# CITY OF ALBUQUERQUE

**RE: 8901 Modesto Ave NE**  
**Grading and Drainage Plan**  
**Engineer's Stamp Date: 9/19/2025**  
**Hydrology File: B20D072**  
**Case # HYDR-2025-00358**

Based upon the information provided in your submittal received 10/03/2025, the Grading & Drainage Plan is **not** approved for Building Permit. The following comments need to be addressed for approval of the above referenced project:

DRAINAGE MANAGEMENT PLAN

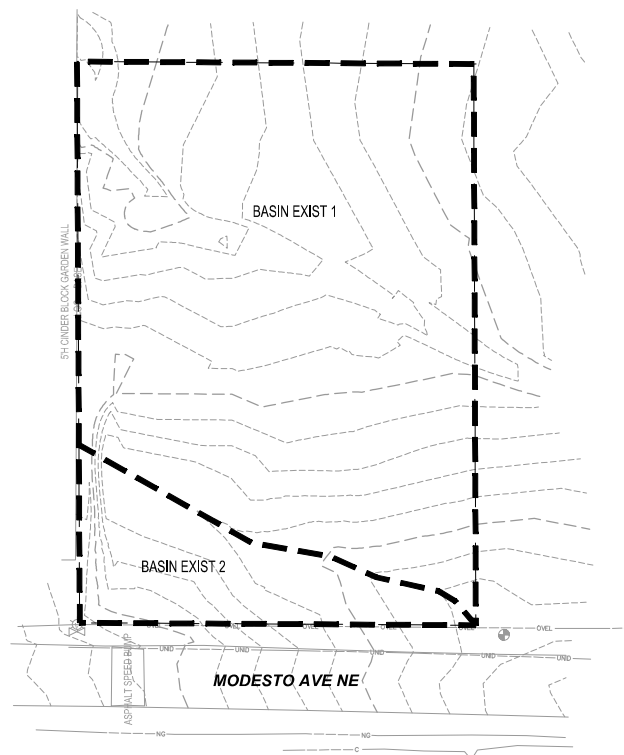
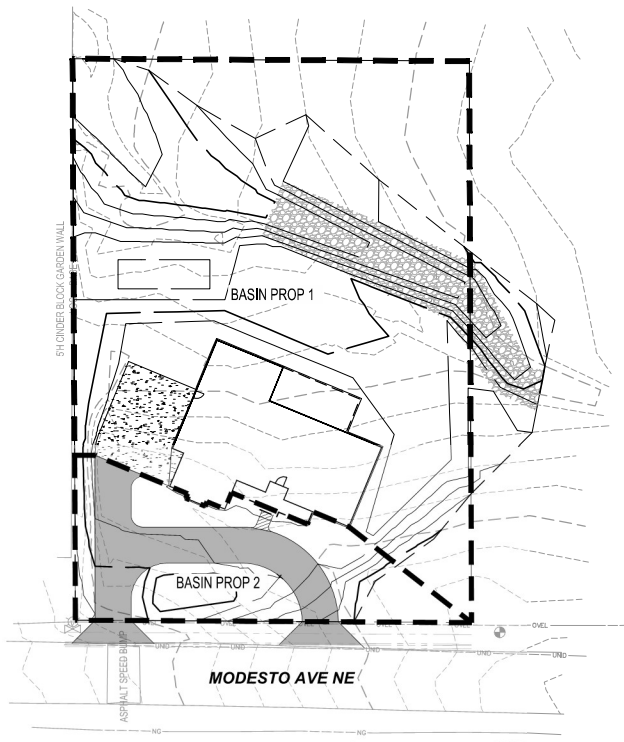
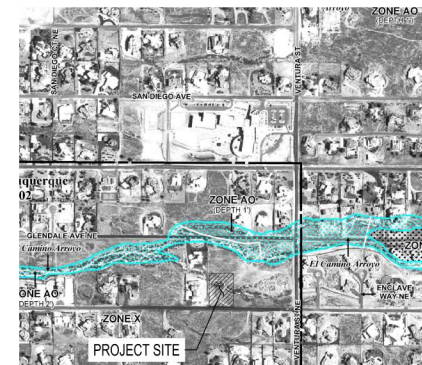
3. Please provide the SWQV calculations for each basin draining to each pond. The stormwater quality ponds need to be sized for the areas draining to them.

GRADING PLAN

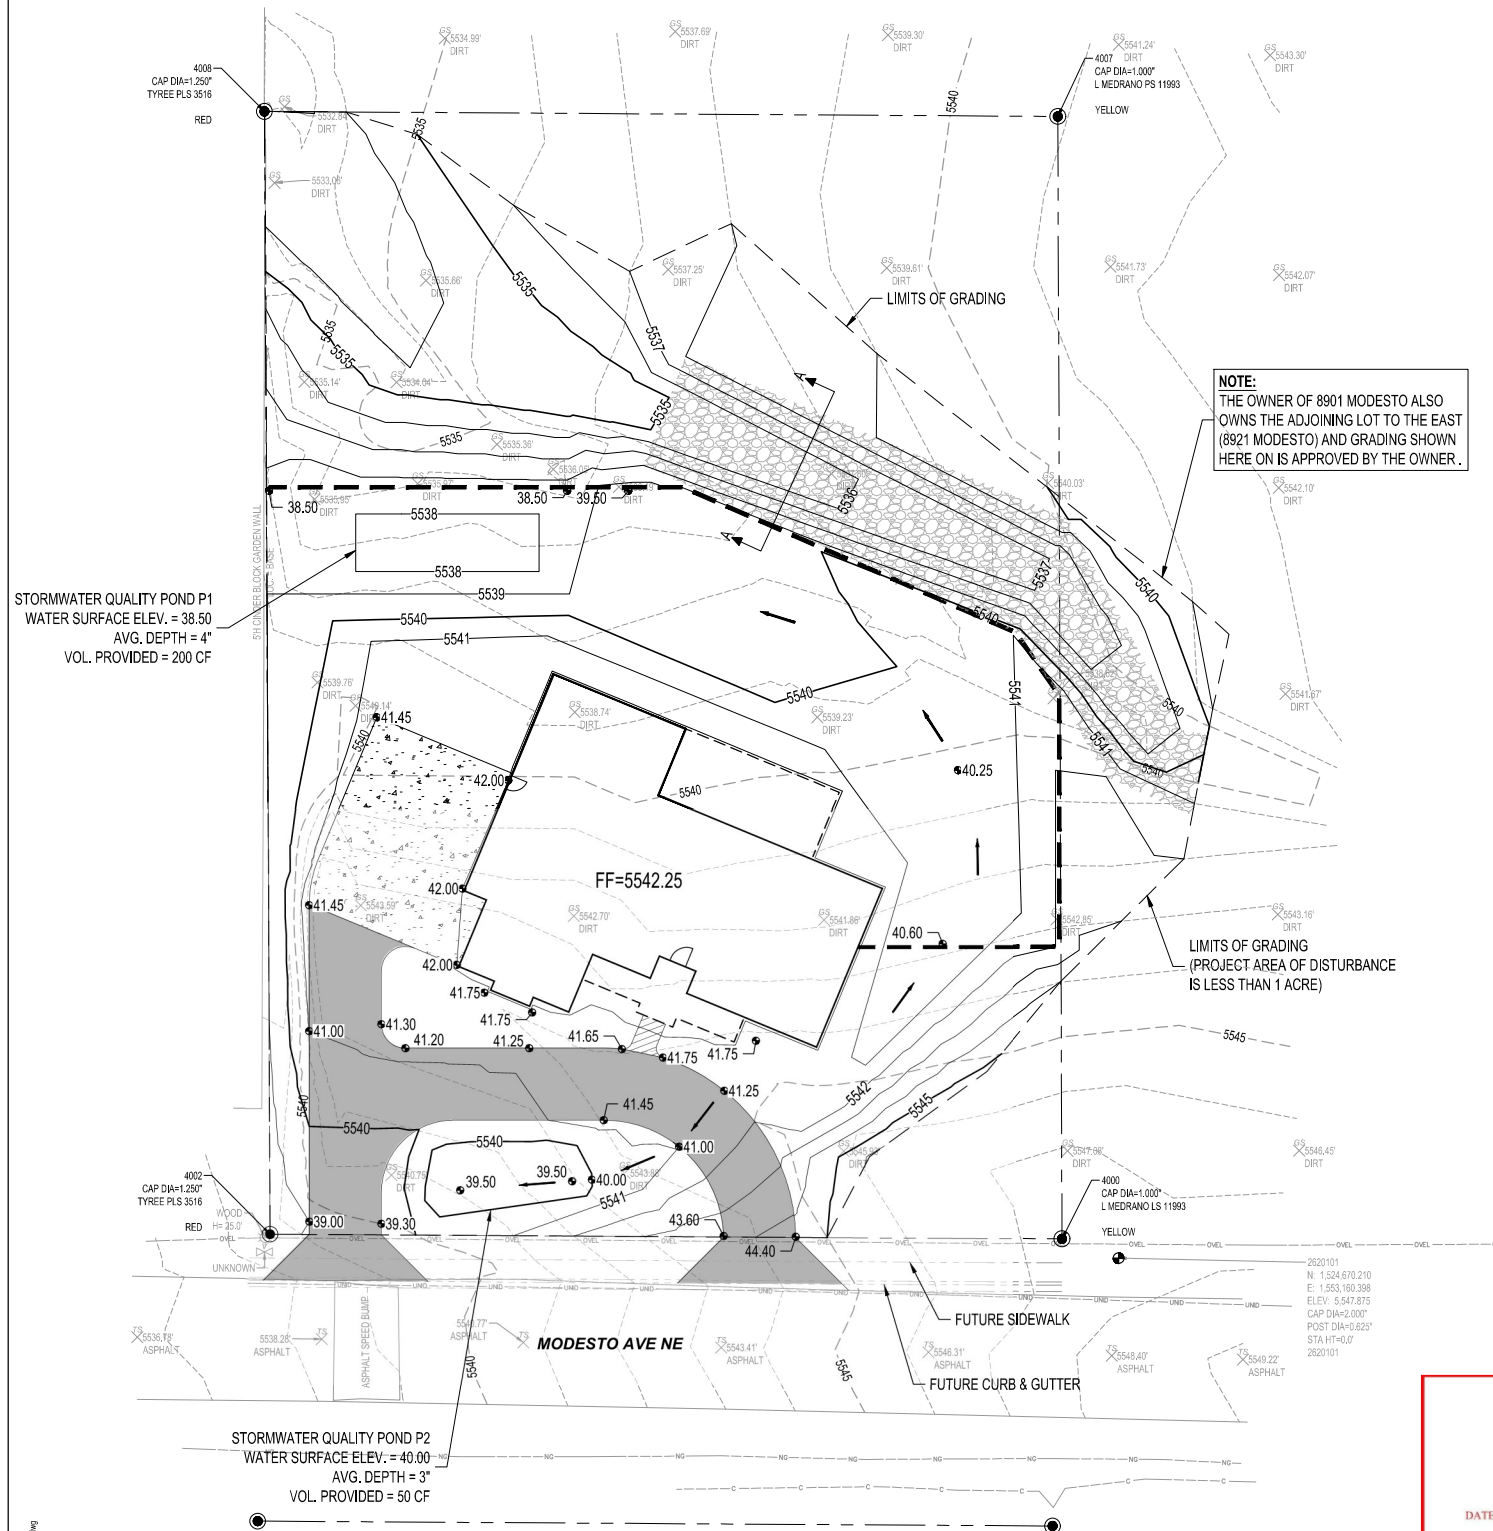
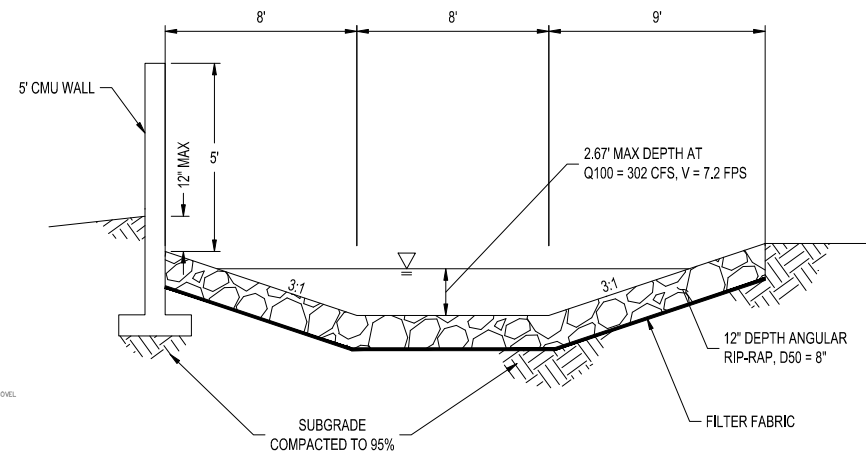
1. Per the DPM, the following must be on the Grading Plan. Please note the Grading Plan must be a stand-alone construction document.
  - a. Please provide a licensed New Mexico civil engineer's stamp with a signature and date.

- b. Please provide the FIRM Map and flood plain note with effective date.
2. Provide management onsite for the Stormwater Quality Volume (SWQV) in accordance with the new drainage ordinance, § 14-5-2-6 (H). Please show the top and bottom of the ponds along with the volume for each pond. The onsite drainage should be directed to these ponds prior to being collected in a private underground drainage system. Please follow the DPM Article 6-12 Stormwater Quality and Low-Impact Development for the sizing calculations. To calculate the required SWQV, multiply the impervious area draining to the BMP by 0.42 inches for new development sites and 0.26 inches for redevelopment sites. The calculations of both the required and the provided volume of each BMP must be shown on the Grading and Drainage Plan. Each BMP should be labeled on the Grading and Drainage Plan with the required SWQV and associated water surface elevation and the 100-year water surface elevation. Landscaping of surface BMPs is also required to be noted on the Grading and Drainage Plan.
